South Downs Society

18th October 2011

Your Ref: FN/36/11
Location: Soldiers Field Stables, Soldiers Field Lane, Findon
Proposal: Regeneration of dilapidated stableyard & associated buildings etc

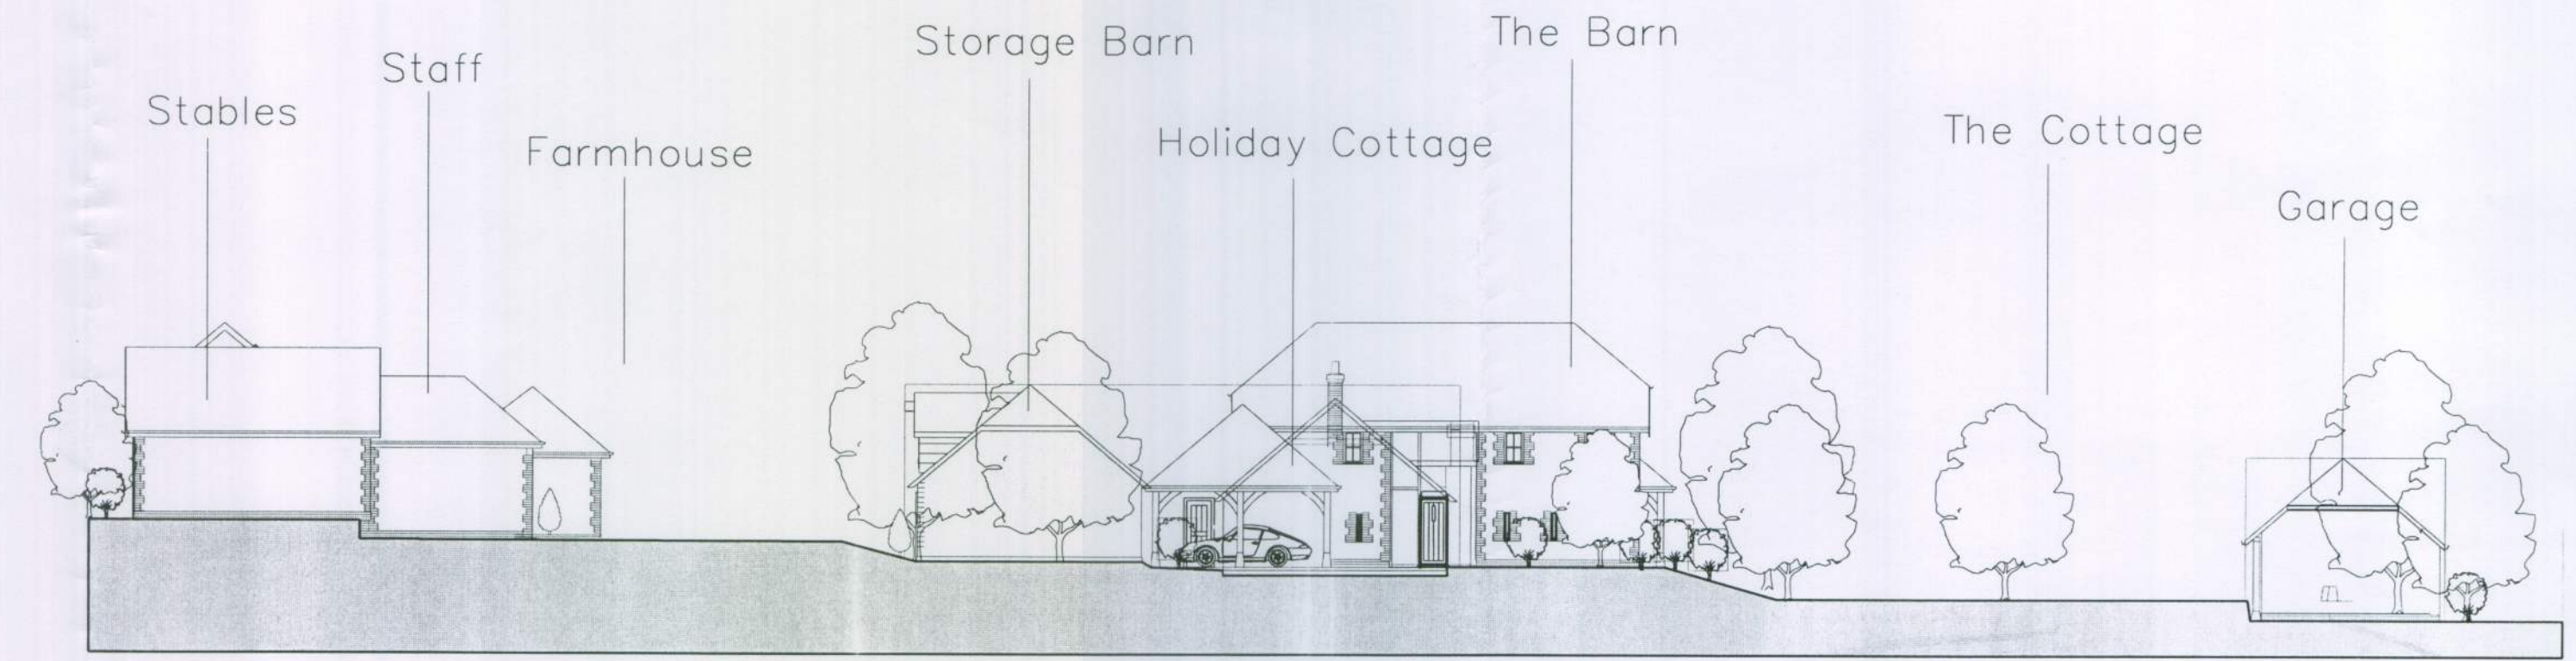
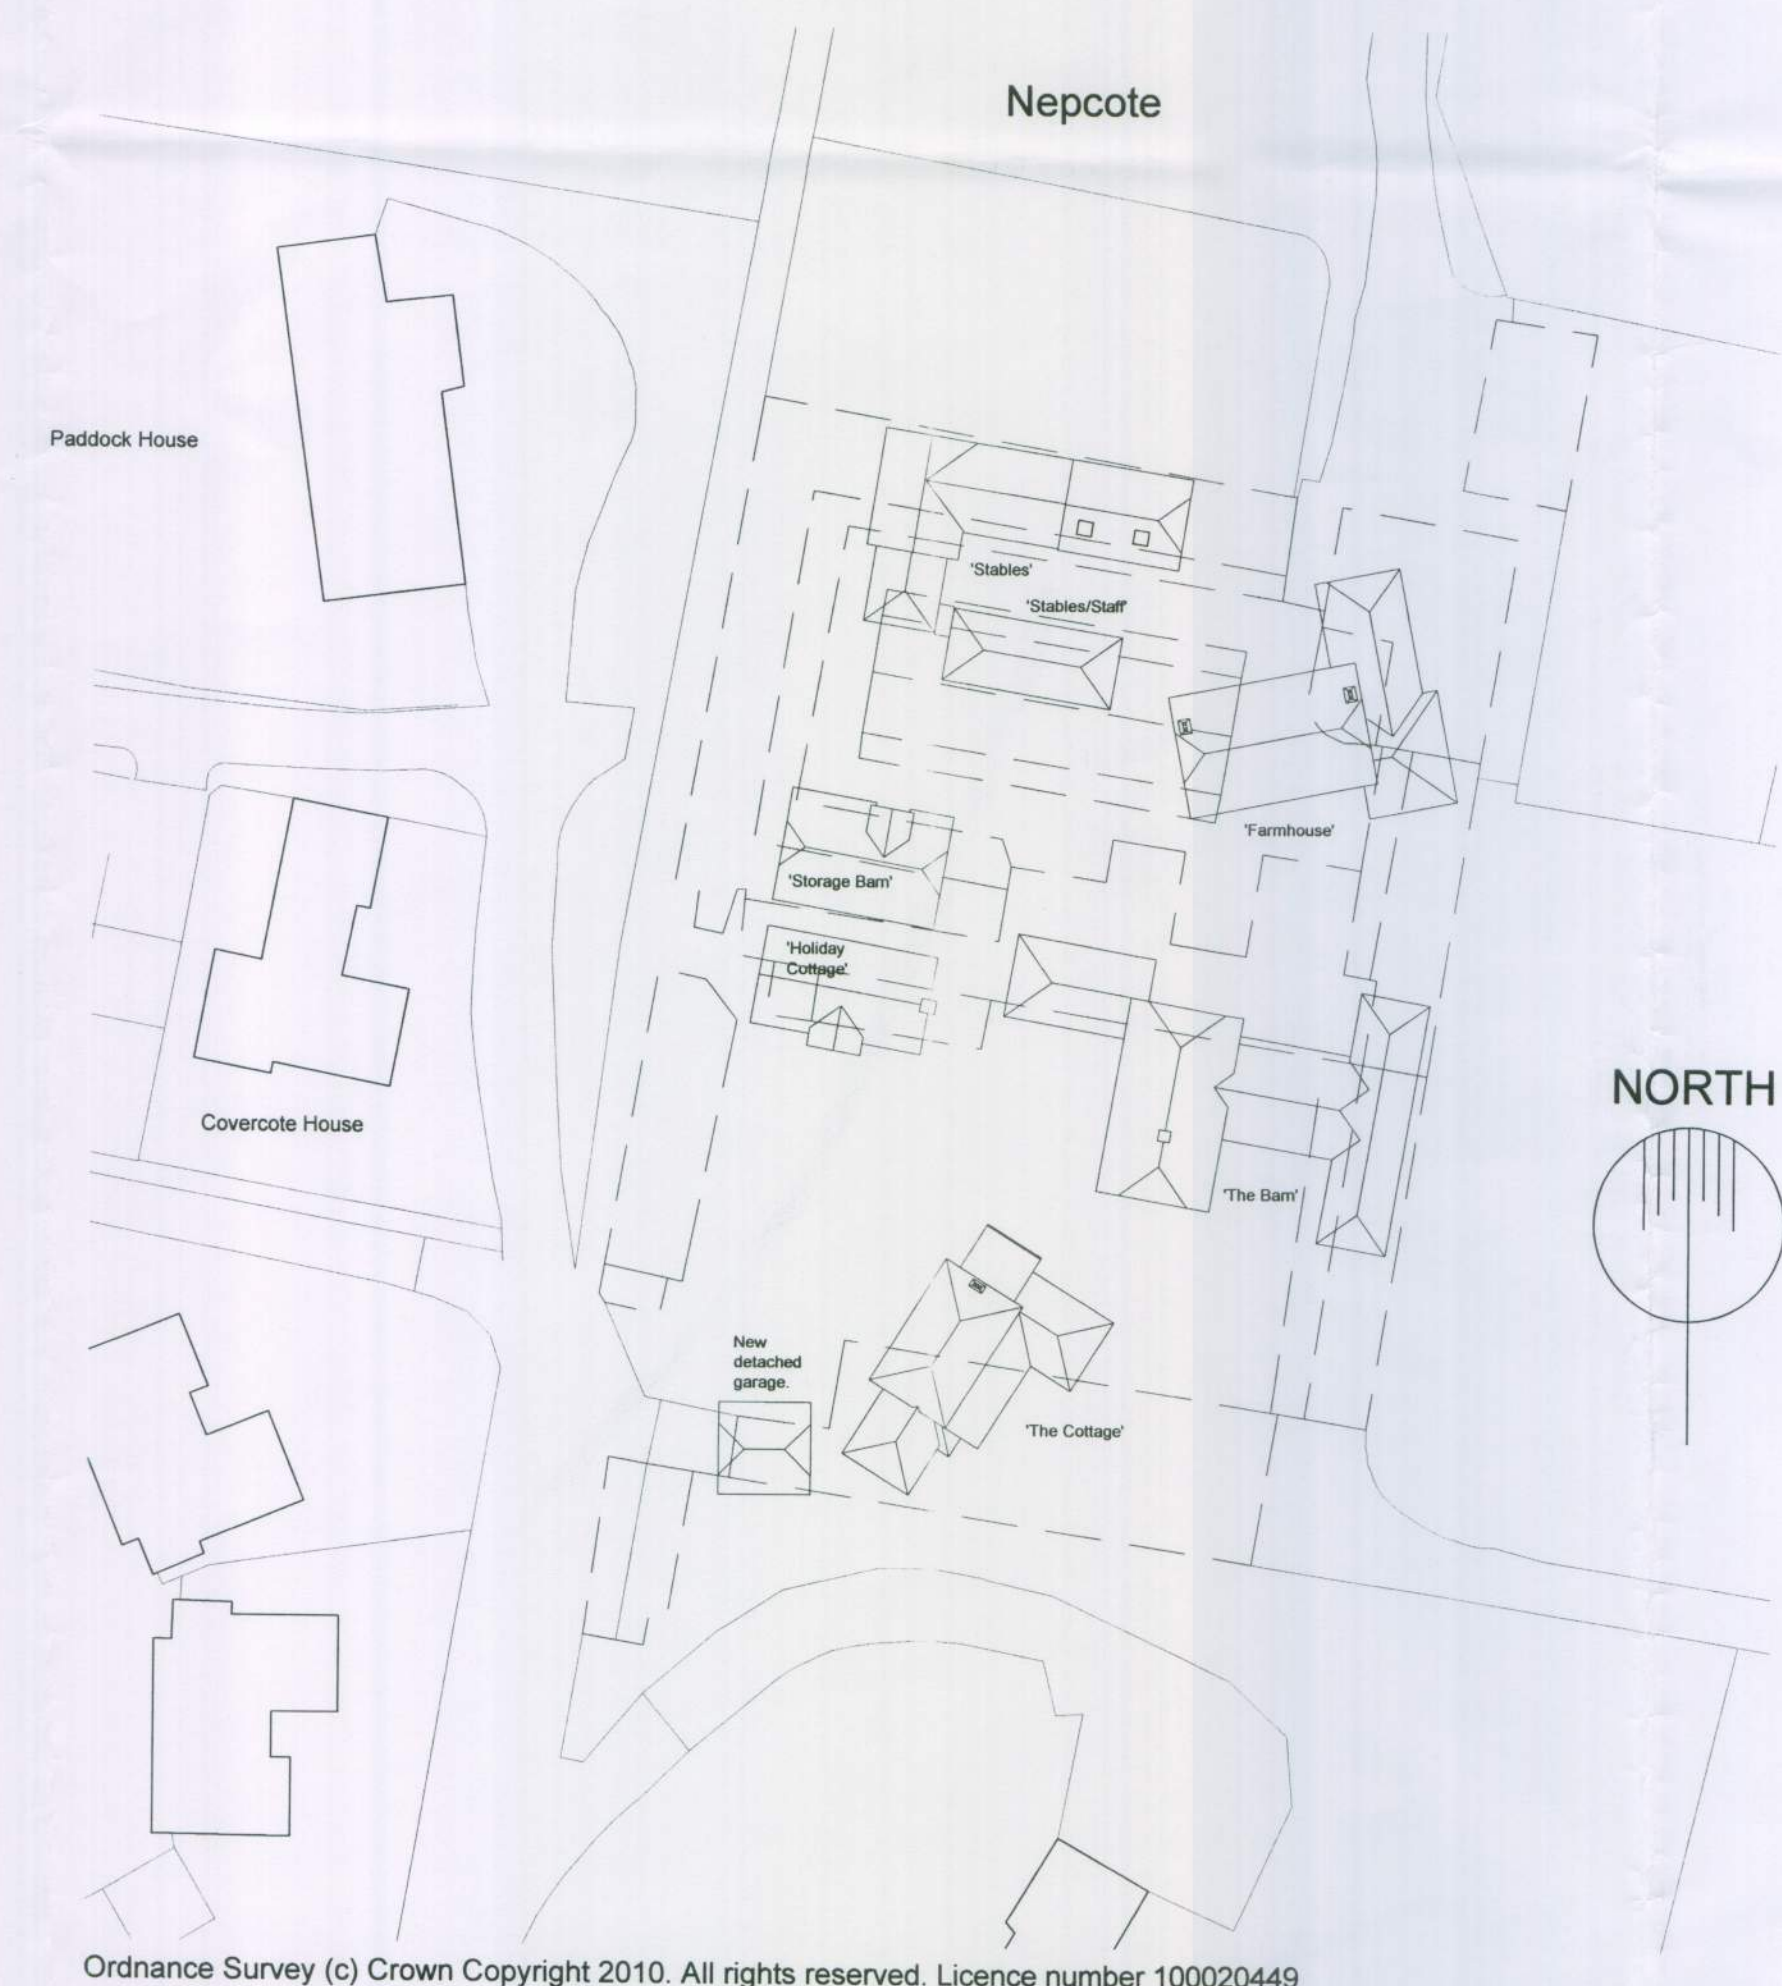
Although not objecting to this application, we would ask that additional planting of indigenous trees and shrubs would be beneficial to provide visual screening of the site from the surrounding countryside.
